**Consultation Response from Mike Hibbert,
KC Waste Strategy(Refuse & Recycling)**

2023/90772 Land at, Penistone Road, Fenay Bridge, Huddersfield, HD8 0AW

Discharge conditions 3 (CEMP), 7 (waste collection), 14 (soft landscape), 17 (boundary treatment), 25 (tree/shrub planting) on previous permission 2020/90725 for erection of 68 dwellings with associated access, parking and open space (revised plans)

Responding Ref: WPS 23-037

Drawing Title	
Construction Management Plan	
Site	
Penistone Road, Fenay Bridge	
Scale @ A1	Date
1:500	06.03.23
Drawn	Checked
BH	.
Drawing No.	Rev.
FB-006	B

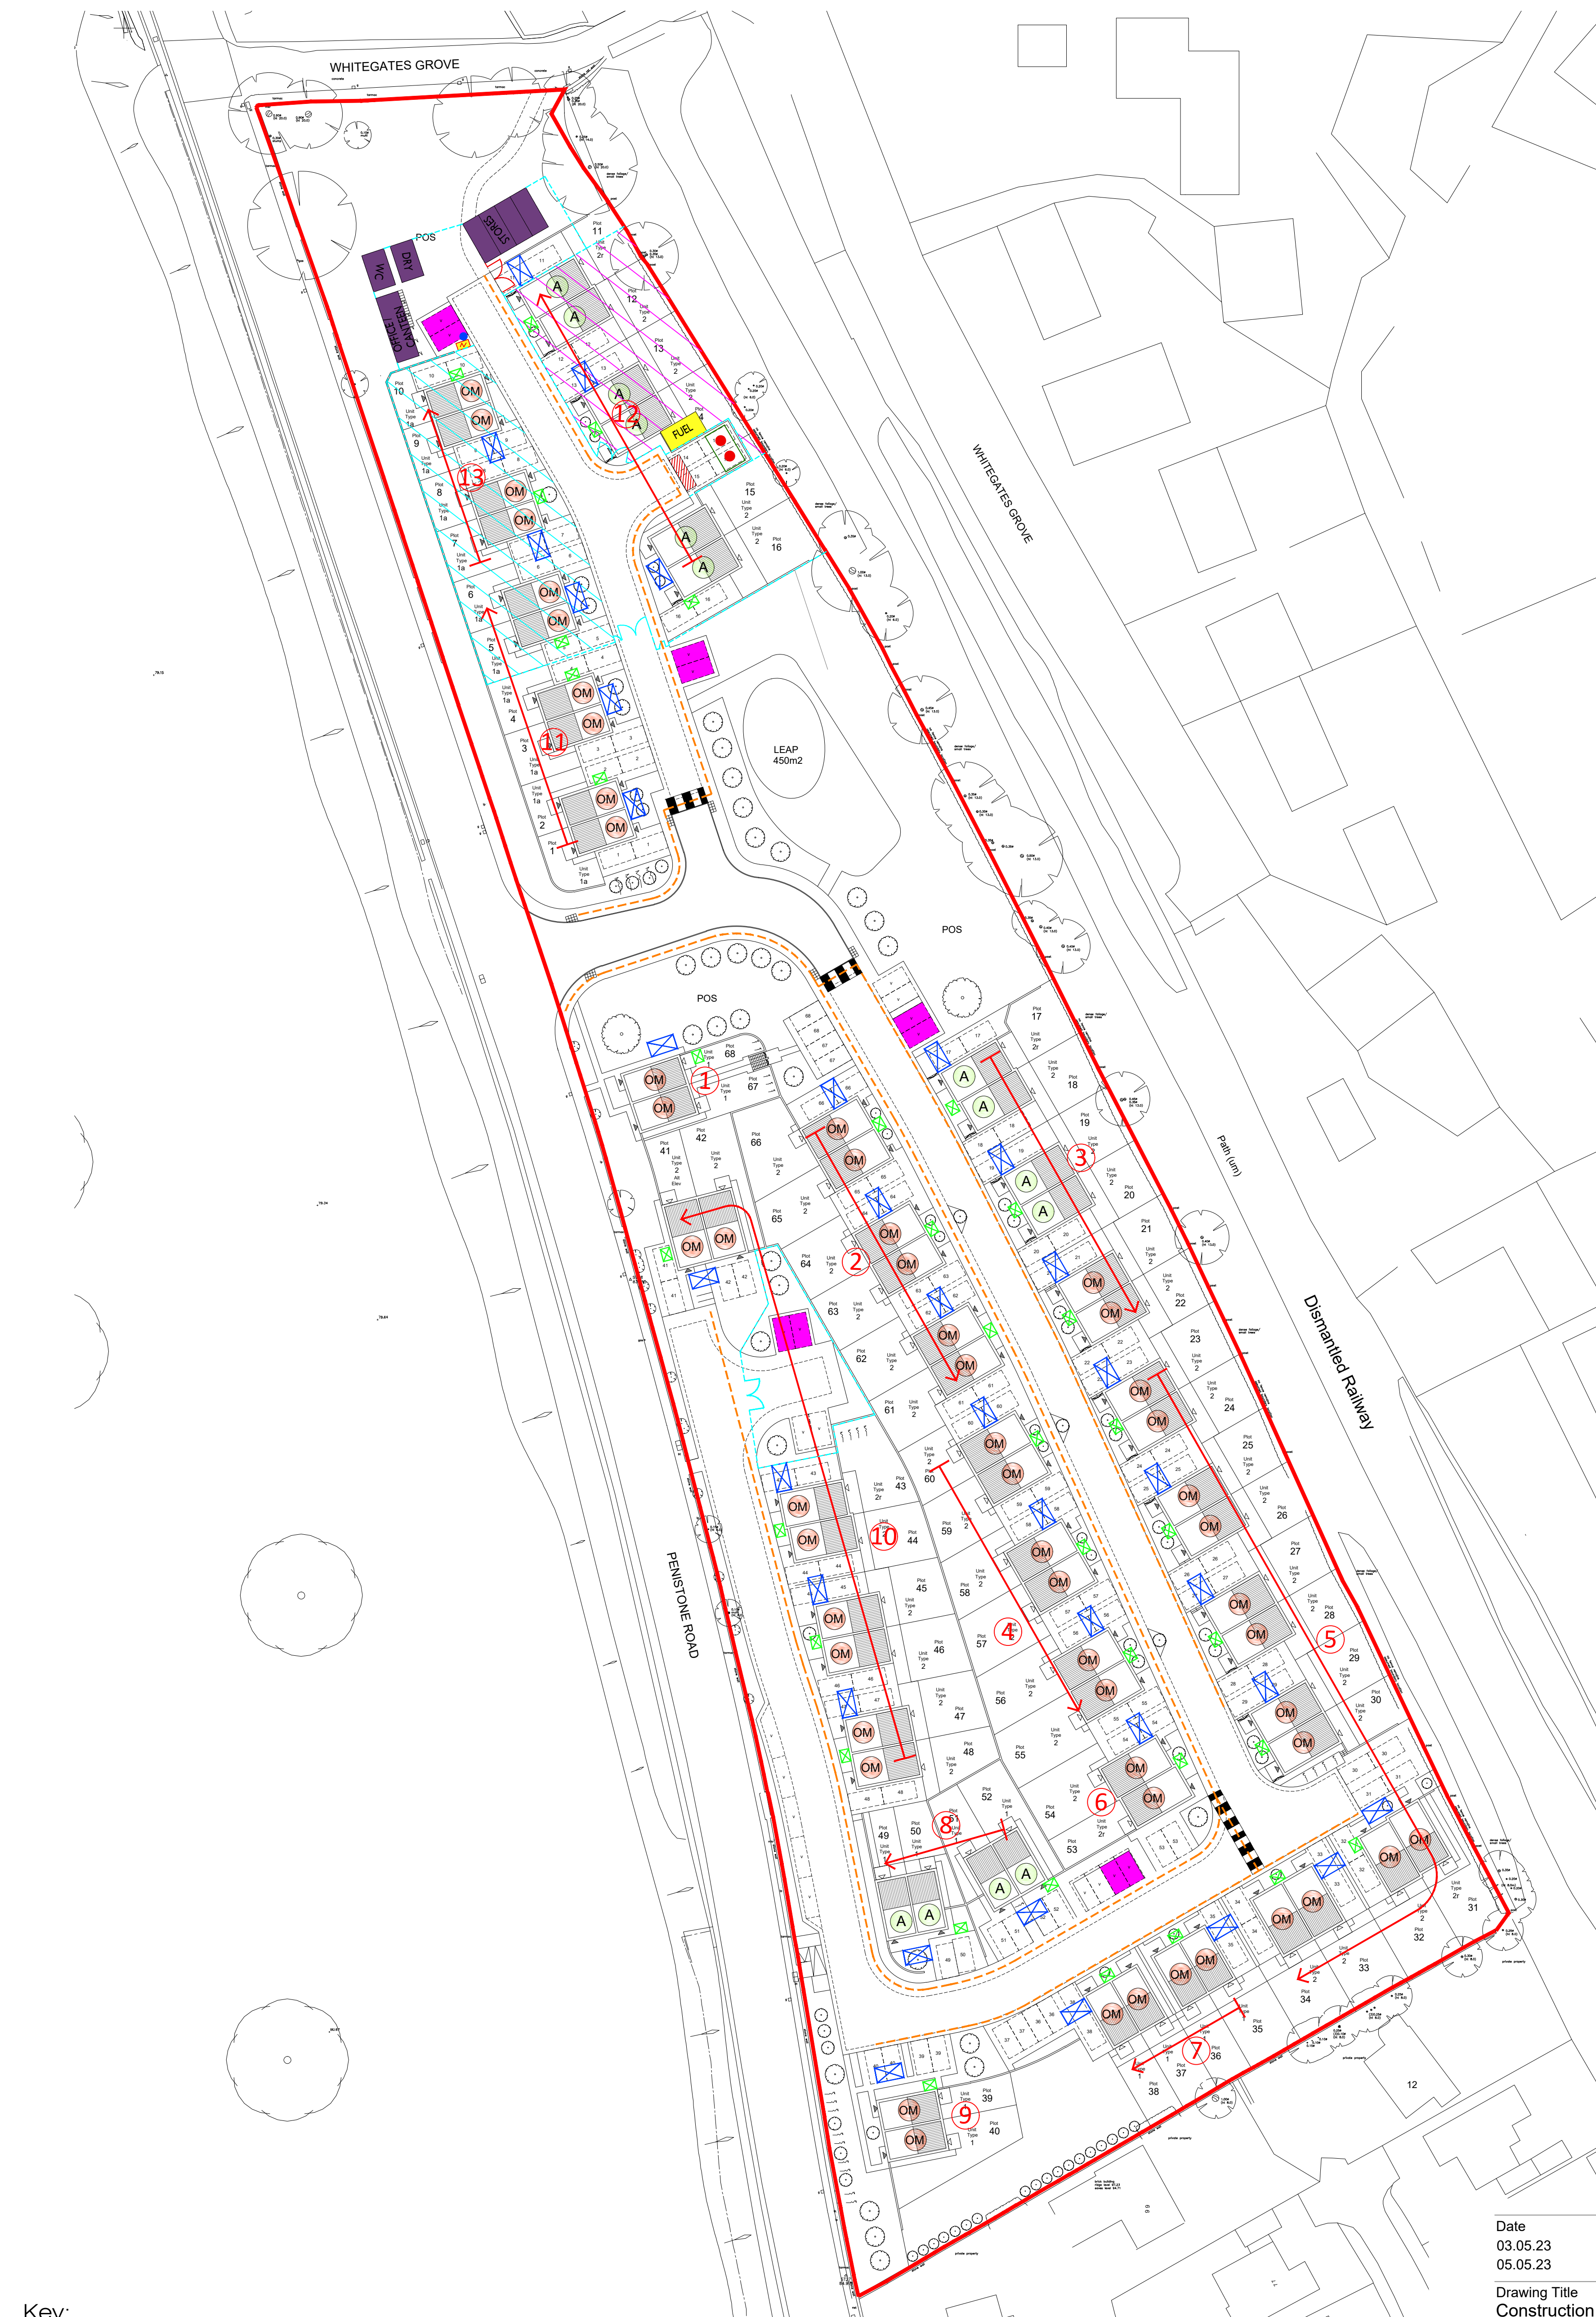
The applicant has submitted a covering letter dated 23 March 2023 and plan ref: Dwg FB-006 Rev B dated 05.05.23 that is annotated with the phasing for the site and the location of temporary bin store locations (as purple rectangles), for use during staged occupation by new residents.

The temporary bin store locations are on visitor parking bays adjacent to Plot 17 (phases 1 to 6), adjacent to Plot 53 (phases 7 to 10) and adjacent to Plot 16 (phases 11 to 13). There are also stores shown on Plot 10 and Plot 42 are in locations that have restricted access for RCV's.

- The Waste Collection Authority will not enter active construction sites with a Refuse Collection Vehicle (RCV). The rationale is to avoid damage to RCV's due to inadequate roadways, potential impact between RCV's or collection crew with contractors' plant/ delivery vehicles and remove the necessity for collection staff to undertake mandatory health and safety induction by the site manager.

- Residents should not normally have to present their 240ltr wheeliebins at temporary Bin Collection Points if the drag distance is more than 25m.
- Temporary waste collection points shall consist of a compound (BCP) for 240ltrs bins, 1100ltrs wheeliebins or in specific cases a closed skip. The frequency of collection

- When residents move into properties the WCA expectation is that residents either have a short drag out of their wheeliebin to a BCP, drop off bags of their waste at the communal collection point/ temporary bin store near the site entrance or the developer can arrange collection from households and deposit waste at the temporary store until such time as the construction phase is released and routine kerbside bin collections from individual dwelling commences.
- If an RCV or skip wagon is entering a site to service a temporary waste store, then there must be demarcation such that a turning head is fenced off from the active construction site. Long reversing manoeuvres by RCV's is a recognised safety risk for both collection staff and members of the public and must be avoided.

Once a meeting has taken place at commencement of construction to establish on site arrangements the WCA will be willing to confirm discharge of Condition 7.
